**WEST SUSSEX COUNTY COUNCIL
STRATEGIC PLANNING CONSULTATION**

**SUBJECT: A/81/17
Roundstone Farm and Shop, Littlehampton Road, Angmering, BN12 6PW**

Applications for removal of condition no 2 of previously approved planning application A/113/88 relating to retail sales restrictions.

ROUNDSTONE FARM
PARKING + VISIBILITY

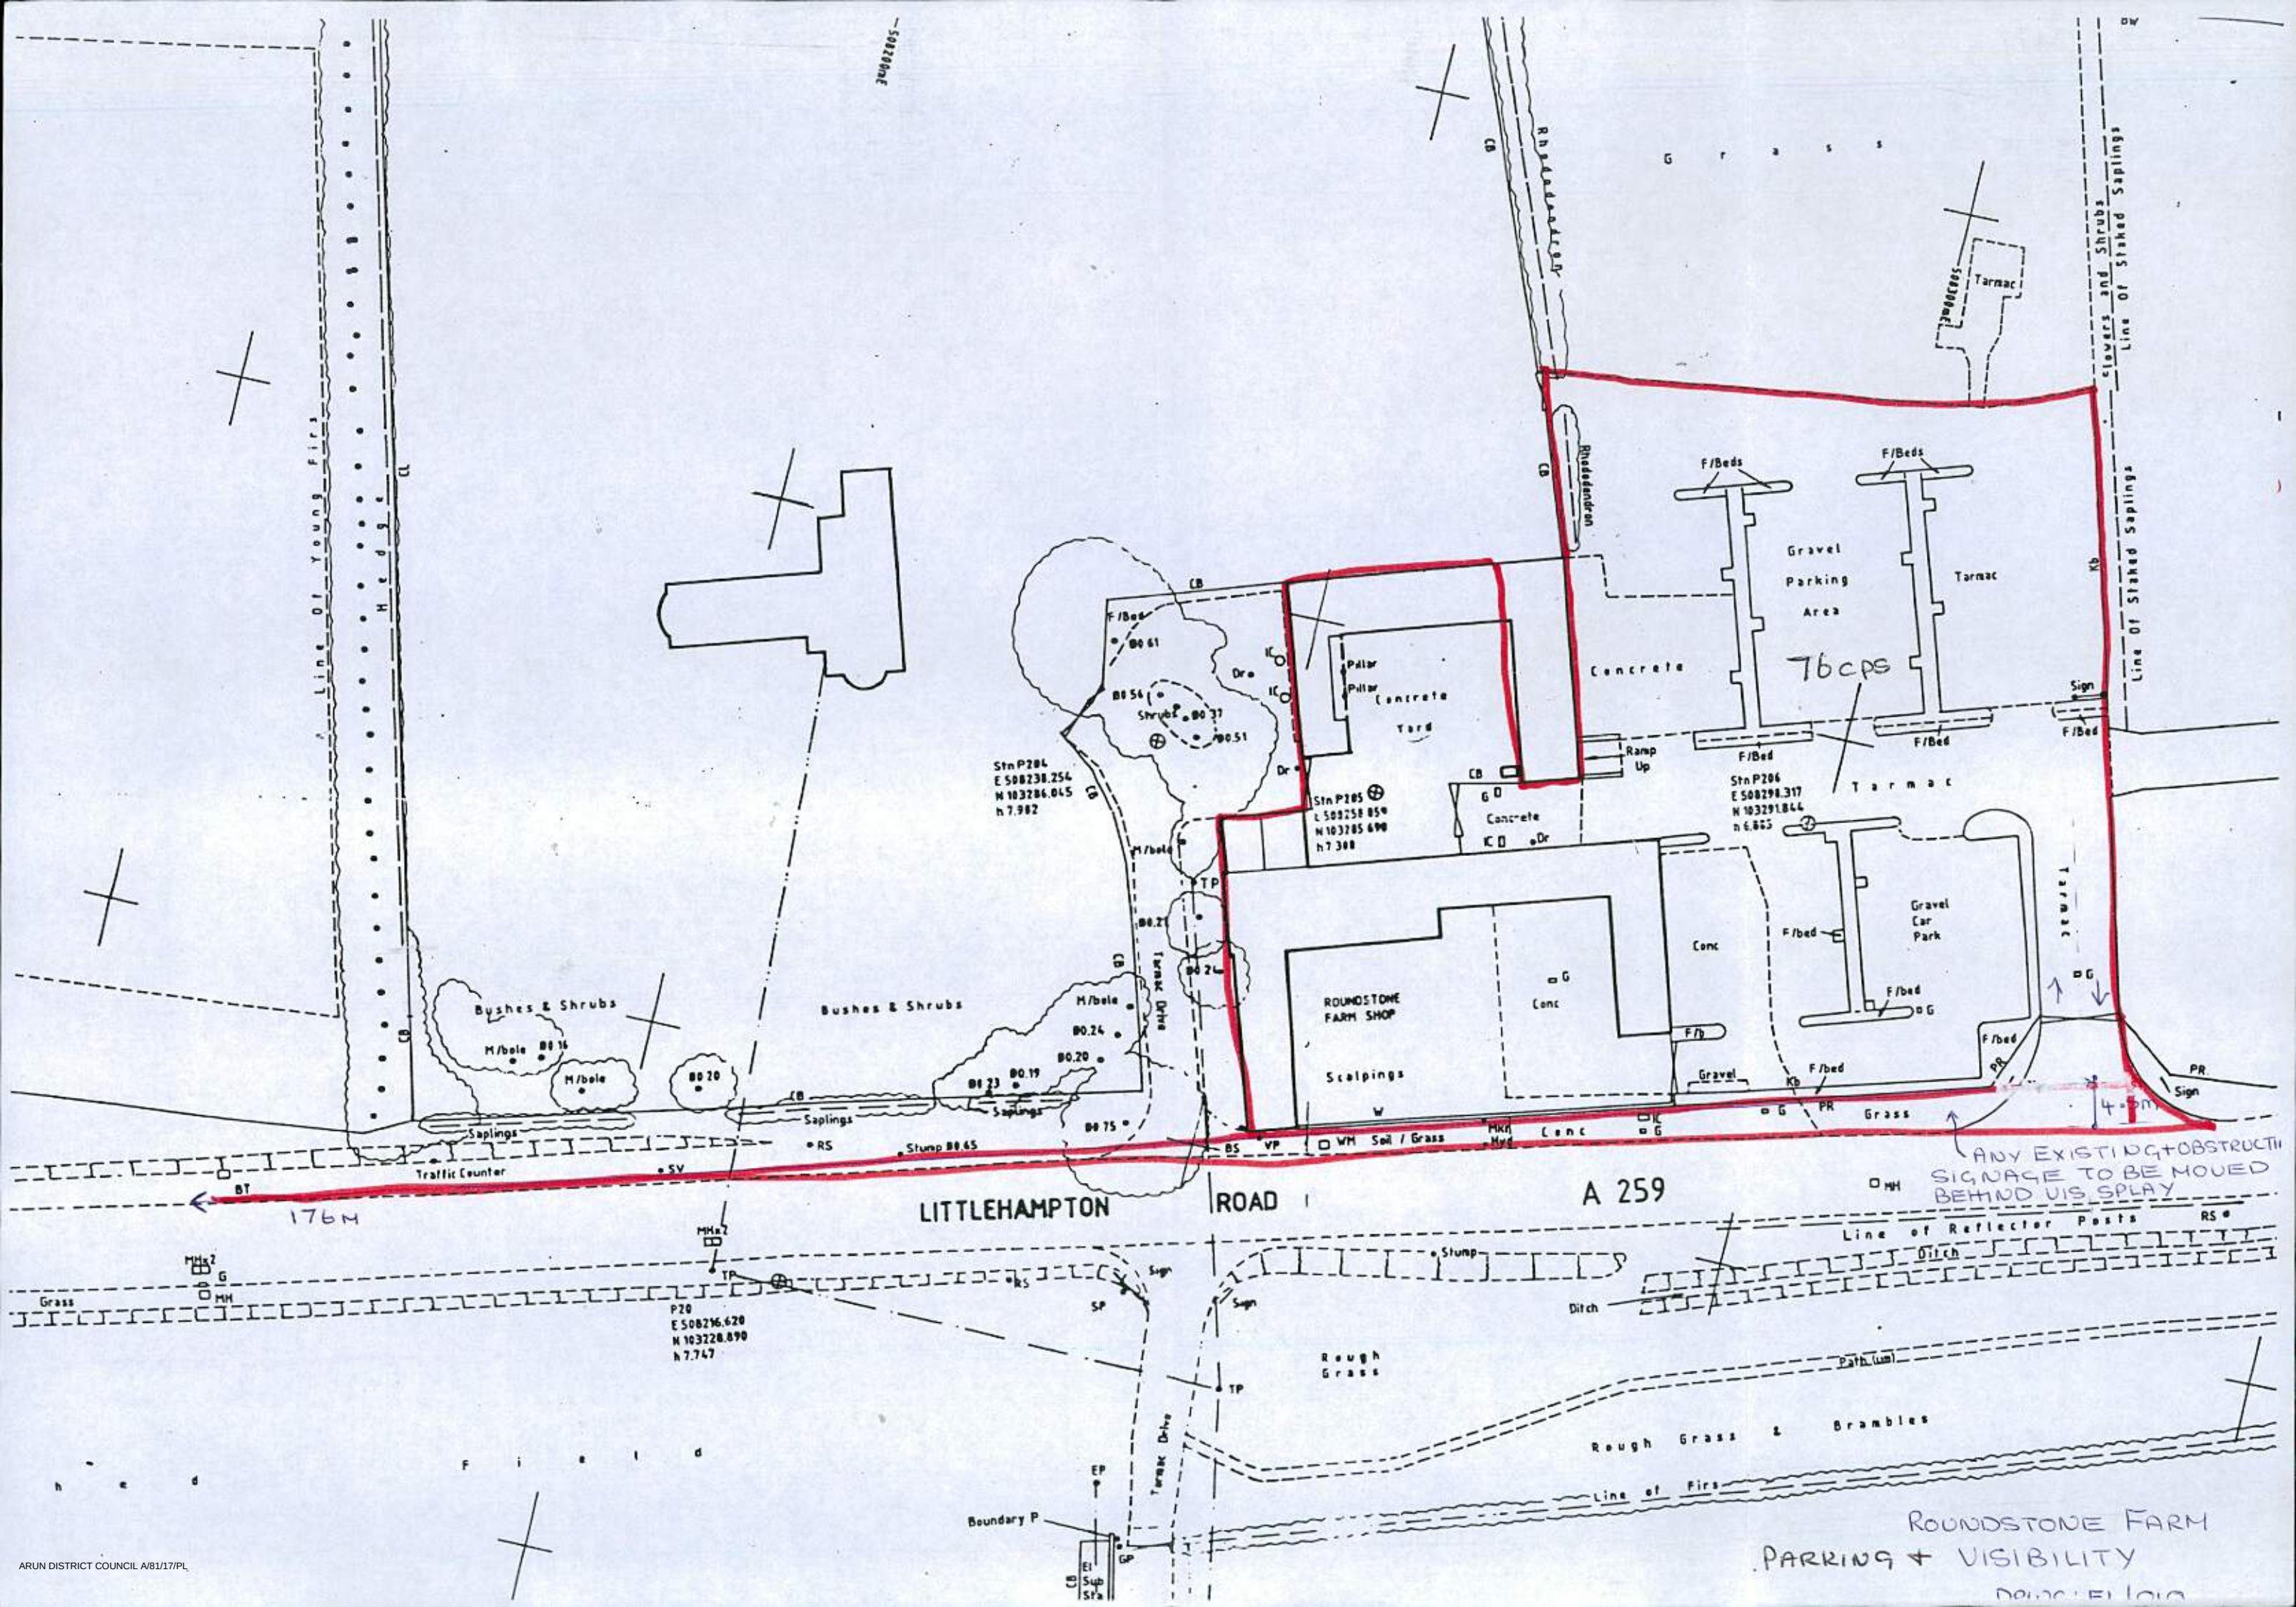
Trips to the site are already catered for in terms of car parking provision. There could be a change to the size of deliveries of the product ranges are to be changed, this therefore should be provided to ensure the existing delivery and servicing arrangements which are in place will be suitable.

As the shop is located on the A27 it is accessible and the access into the site is wide with good visibility. Therefore apart from confirmation over the size of delivery vehicles and where these many/may not load/unload no objection is raised.

No part of the retail store extension shall be first occupied until such time as until a Servicing Management Plan for has been submitted and approved in writing by the Local Planning Authority. This shall set out the arrangements for the loading and unloading of deliveries, in terms of location and frequency, and set out arrangements for the collection of refuse. Once occupied the use shall be carried out only in accordance with the approved Plan.
Reason – to safeguard the operation of the public highway.
